AW/336/20/HH

West House 151 Barrack Lane Aldwick PO21 4ED

Proposed conservatory/vestibule extension, pitched roof to existing detached flat roof garage & minor improvements to garage doors.

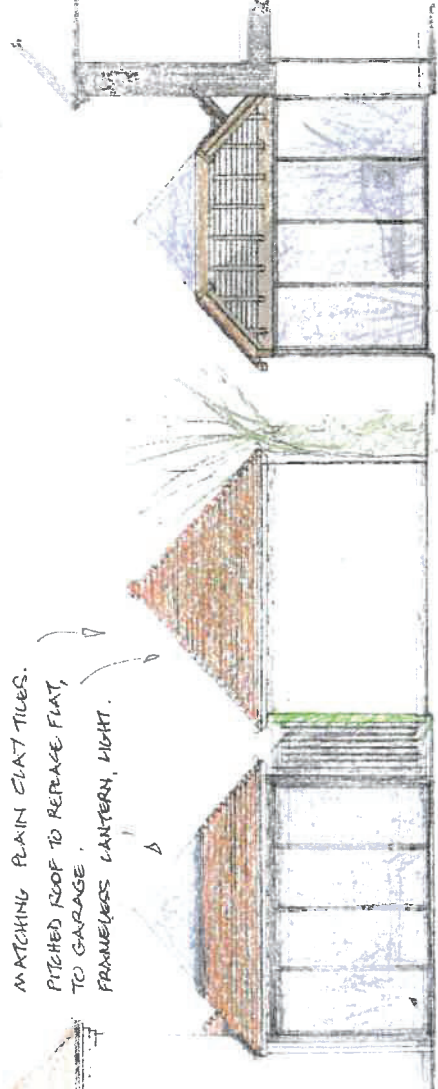
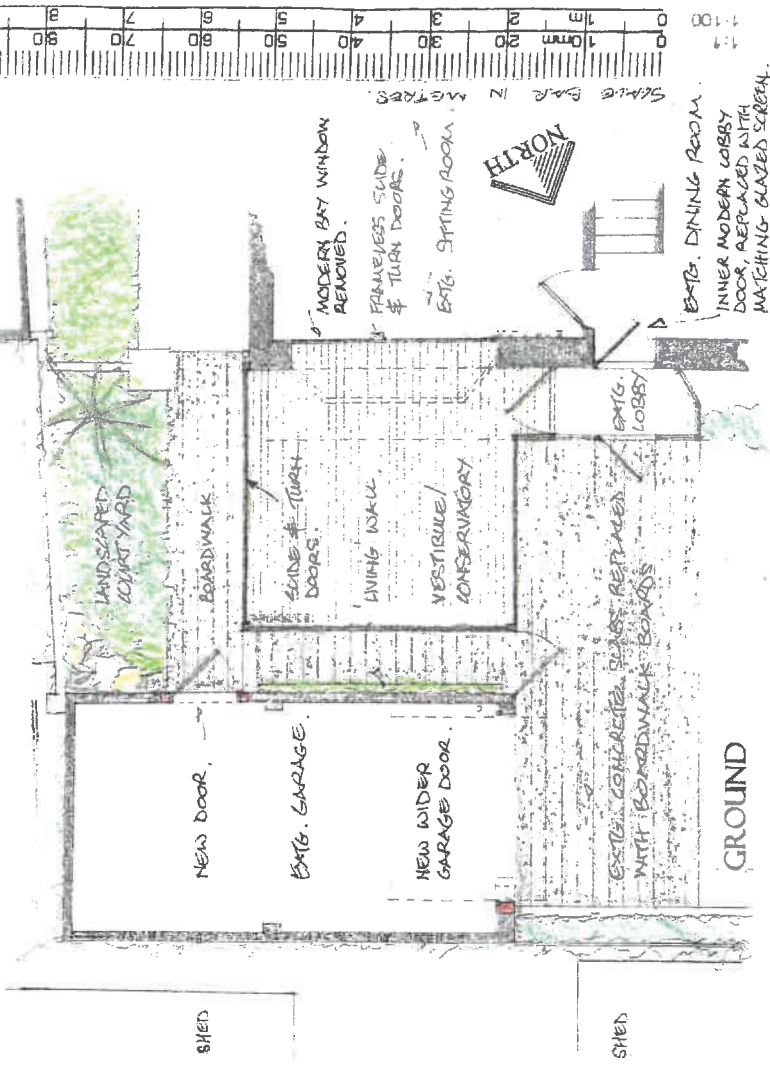
The frameless slide and turn glass panels, like the extension (discussed below) will introduce a very modern element into the building, whilst also altering an existing opening. The justification is such that it will allow additional light into the property, and this seems understandable. The use of this modern element could, if successfully undertaken be striking!

The proposed extension is very modern in appearance and it would be visible from the front elevation of the property which at present is very pleasant.

The proposed roof of the structure is of an interesting design; the use of the part tiled, and part glazed approach is not one I would normally associate with what is essentially a listed cottage. However, the points raised by the applicant regarding the use of materials for the roof, and that the intention is for the room to be as transparent as possible are noted and understood. It is therefore thought that the use of the pyramid light (in association with the glazed walls) would attempt to reduce the impact of the structure on the existing building. Such a look could be striking and represent the further evolution of the building!

If to be considered suitable, the quality of the details and material used will have to be very high in order to achieve a high-class piece of design. If you are minded to approve the application, please condition details of the materials and glazing.

This element of the proposal is supported as it will ensure that the modern garage building better reflects the character of the listed building. A similar approach has been adopted at the neighbouring property. Materials as noted, should reflect that already present, and if needed could be conditioned if you are minded to approve the application.
